# Urban Design Review Panel Report - Revision 1

## 500 Coventry Road, Ottawa

**RE: Urban Design Review Panel Report – Revision 1  
Site Plan Control Application  
500 Coventry Road, Ottawa**

Enclosed, please find responses to the Urban Design Review Panel's comments provided on February 2, 2024, regarding the Site Plan Control application for the property municipally known as 500 Coventry Road, Ottawa.

DRAWING NO. SPA301
REV. 3

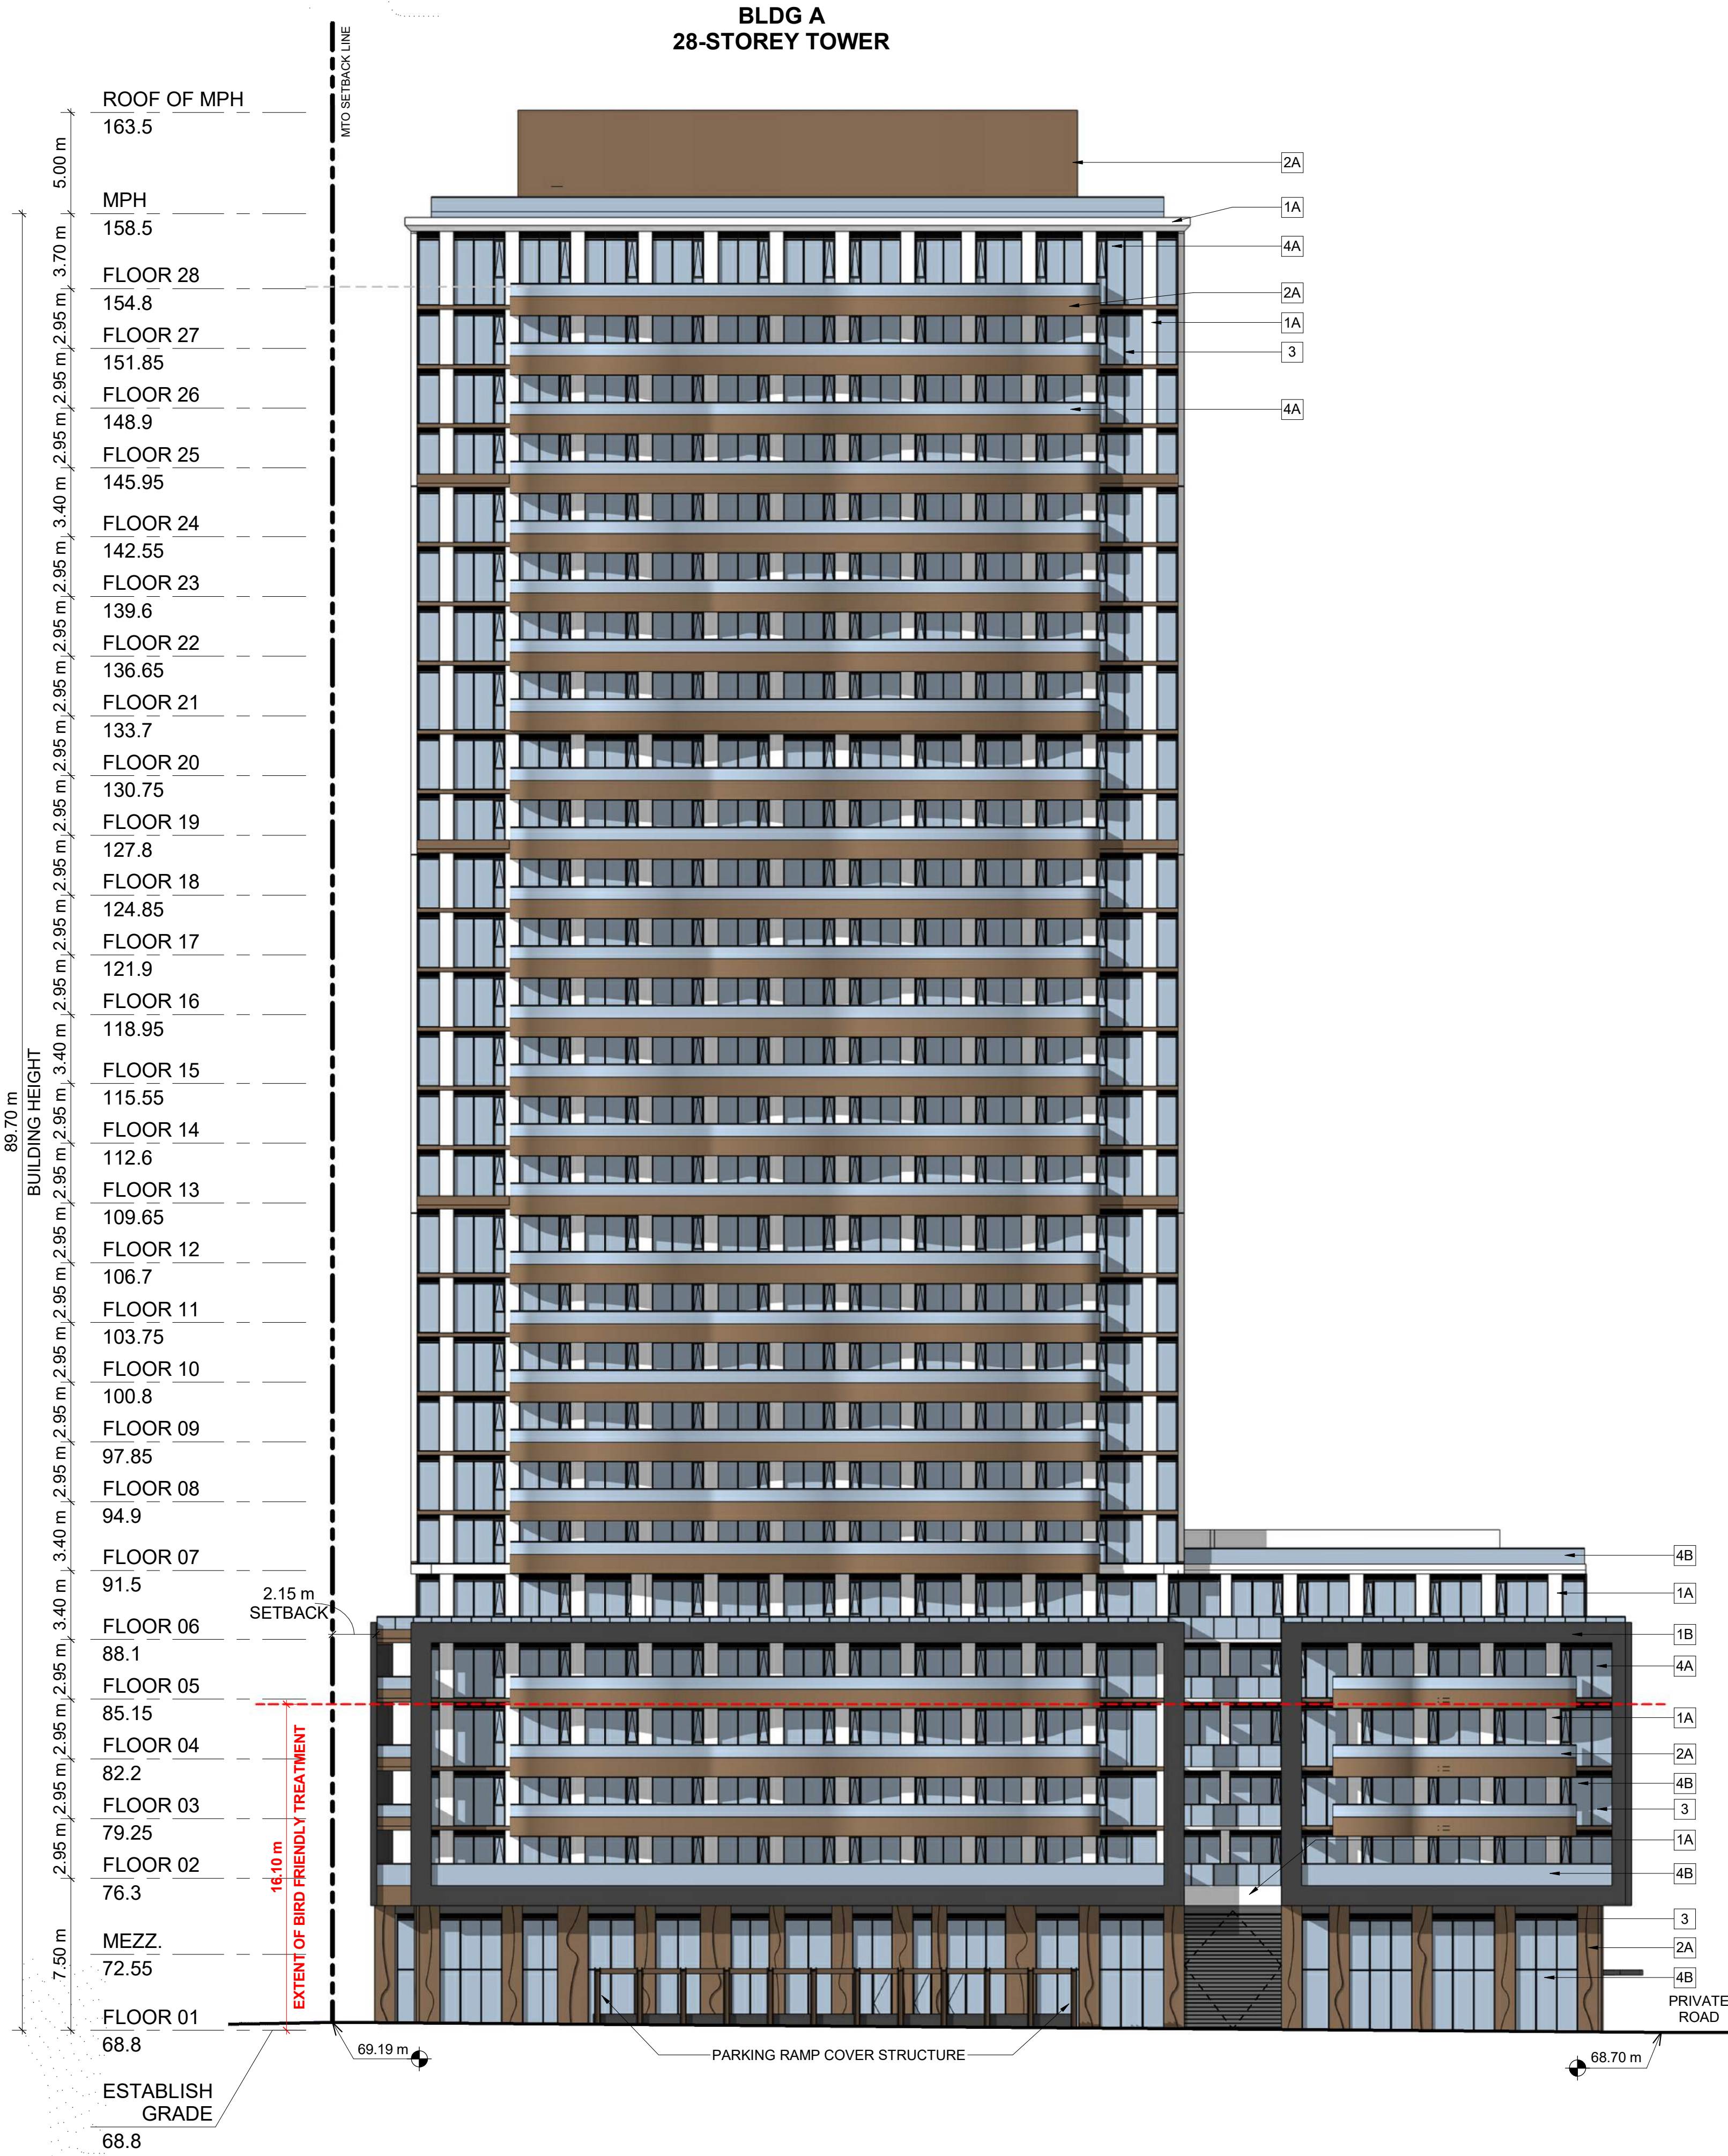
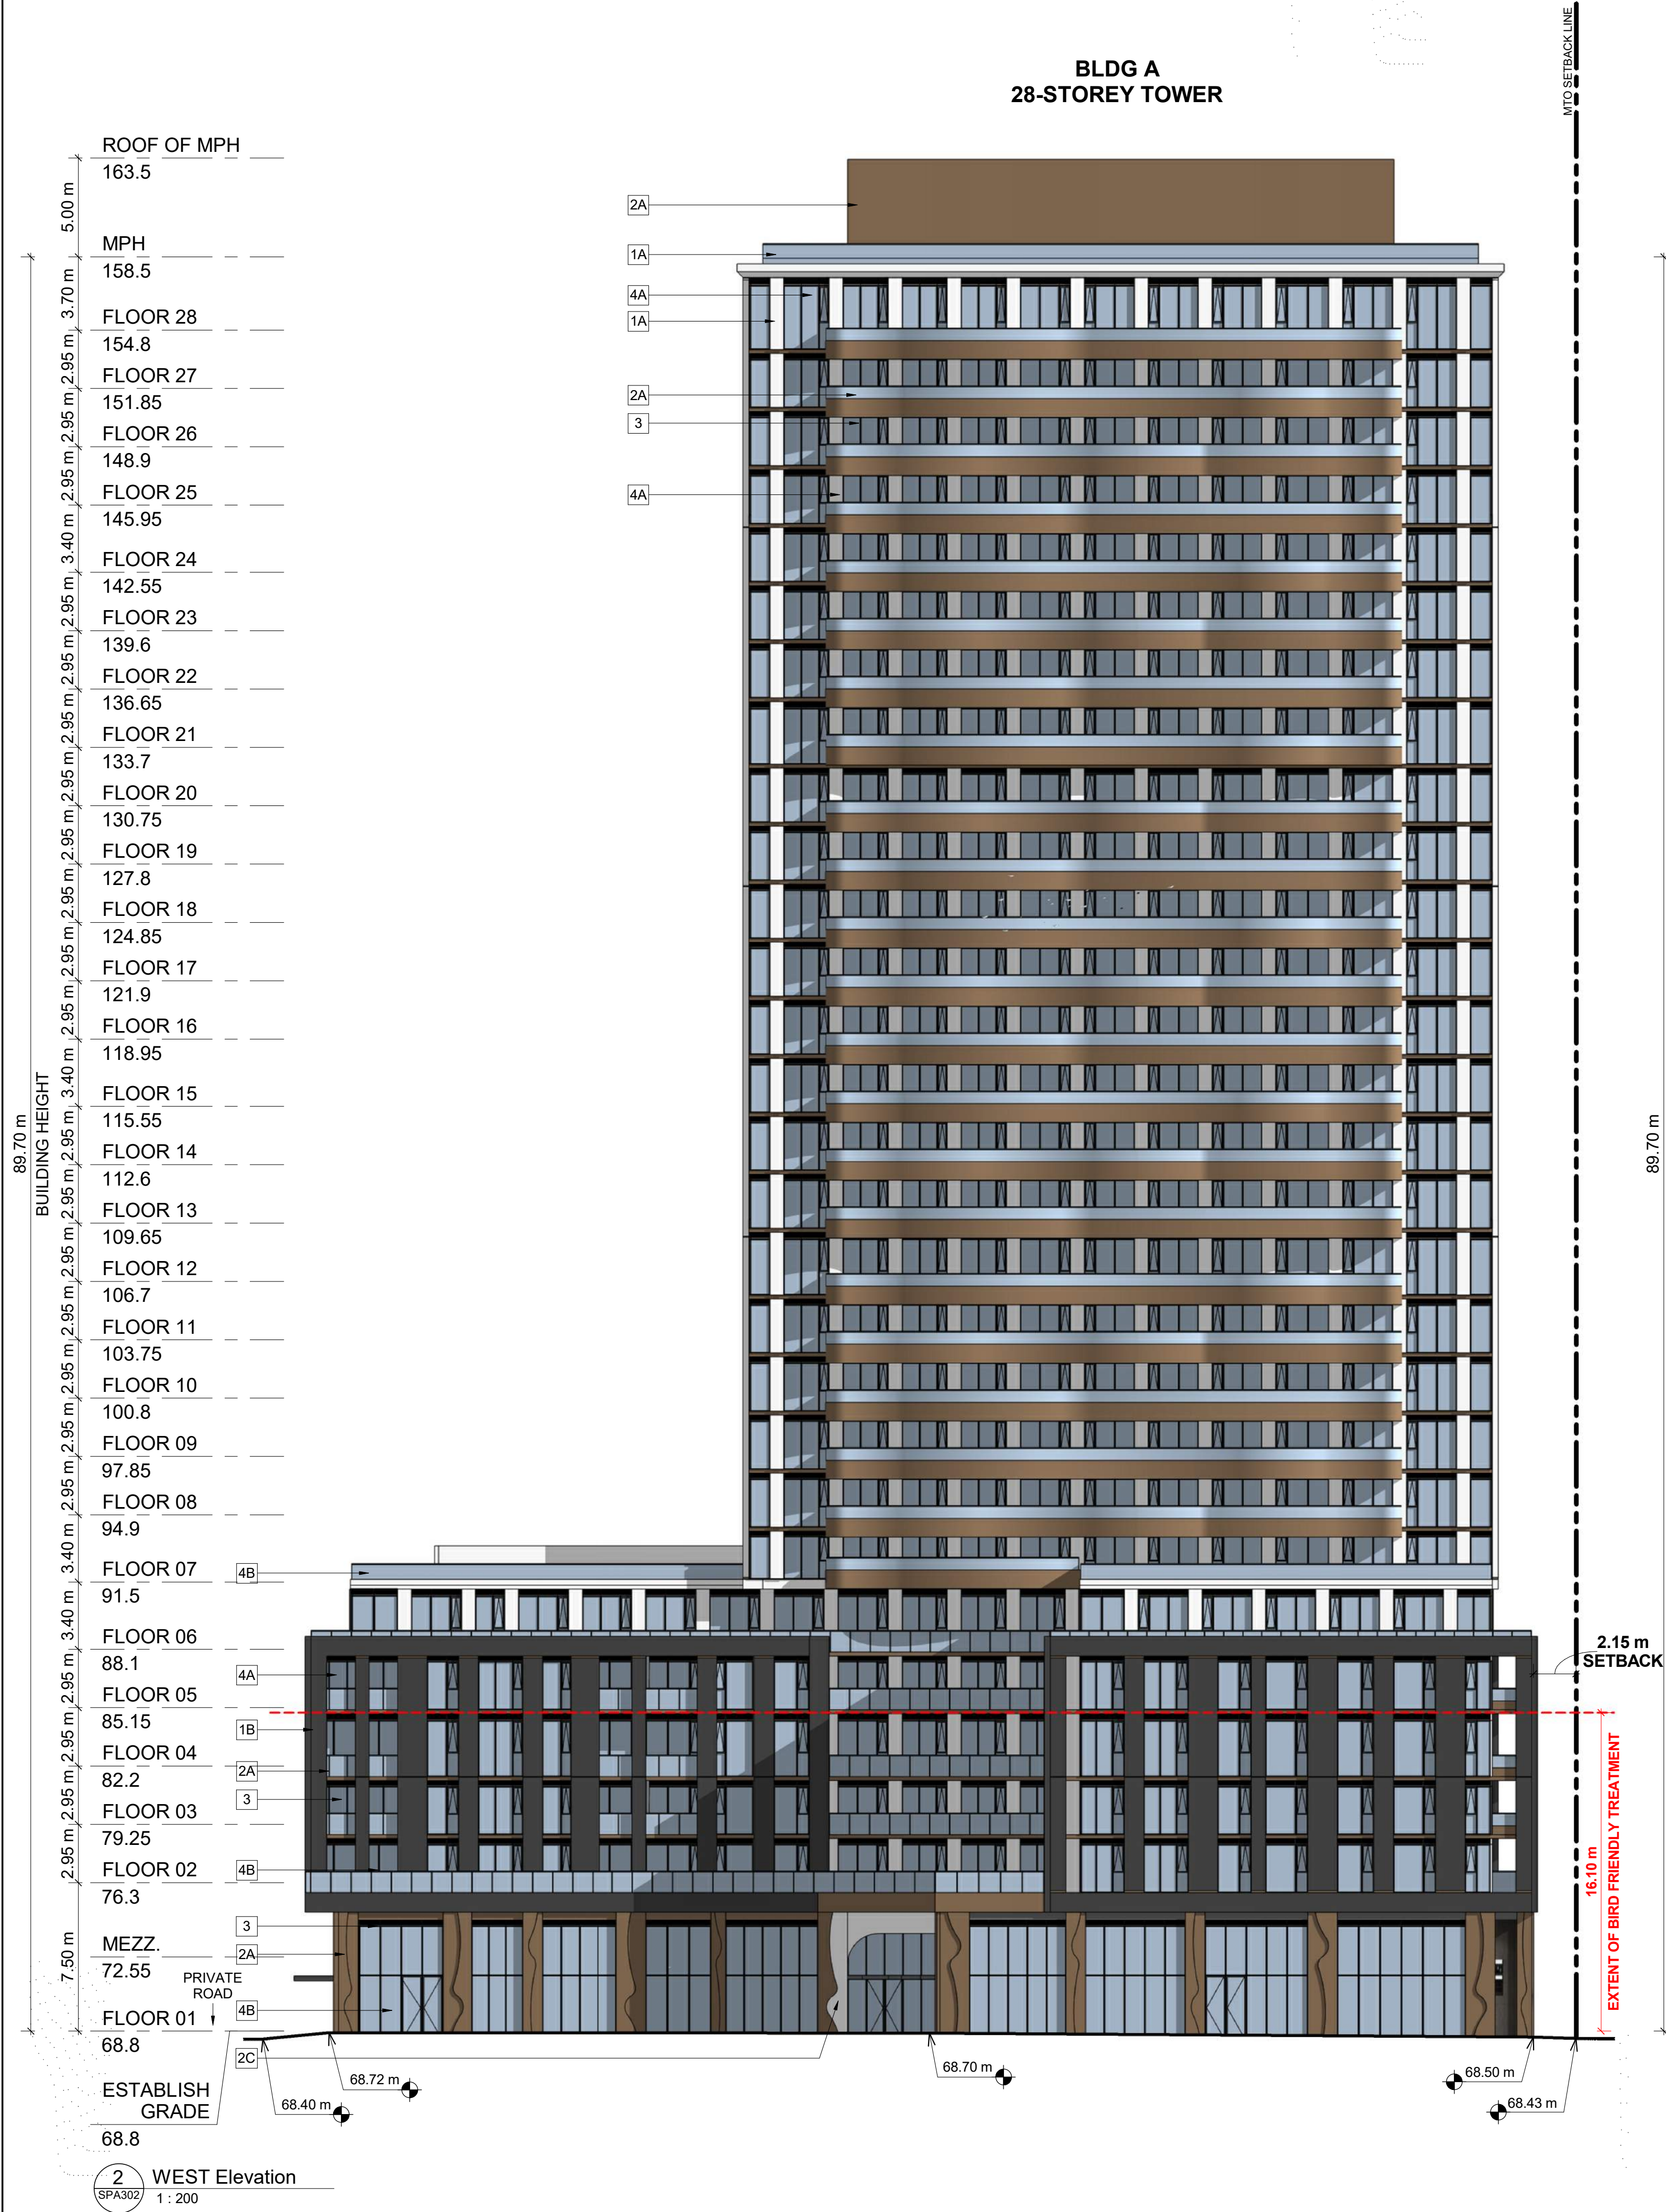
10. The Panel recommends furthering the undulating balconies and water motif to the north and south elevations to create a play between the orthogonal and undulations.

11. The Panel recommends expressing the architecture of the tower 'in the round', integrating the waterfall features with the solidity of the side elements, and softening the contrast between the two.

31. The Panel appreciates the water motif of the tower's architectural expression. The undulations are particularly appreciated with great potential for capturing and playing with light.
- The Panel recommends leaning more into the undulating balcony articulation to further advance the waterfall motif.
  - The Panel recommends wrapping the undulating balconies around onto the north and south elevations of the tower, at least partially if not fully.

32. The Panel has some suggestions to reduce the contrast between the vertical pre-cast white strips on the elevations, and the undulating balconies of the east and west elevations.
- The Panel recommends as one approach, adding a softness to the vertical white pre-cast element, and further exploring how this waterfall motif could also be integrated to soften the vertical strips.

**Response: We appreciate the suggestion. The undulation of the balconies is intended to achieve a certain effect on the east and west elevations mainly and are purposefully not being proposed on North and South elevations to achieve a contrast and maximize the effect where they are being propose.**

**Response: We appreciate the suggestion. The undulation of the balconies is intended to achieve a certain effect on the east and west elevations mainly and are purposefully not being proposed on North and South elevations to achieve a contrast and maximize the effect where they are being proposed.**

**Response: We appreciate the suggestion. The undulation of the balconies is intended to achieve a certain effect on the east and west elevations mainly and are purposefully not being proposed on North and South elevations to**

**achieve a contrast and maximize the effect where they are being proposed. We purposefully located balconies where needed and prefer limiting the amount of slab projections where not necessary.**

**Response: We appreciate the suggestion. As we continue to refine the design we will consider if a stone-like material can be used to anchor the waterfall motif as suggested.**
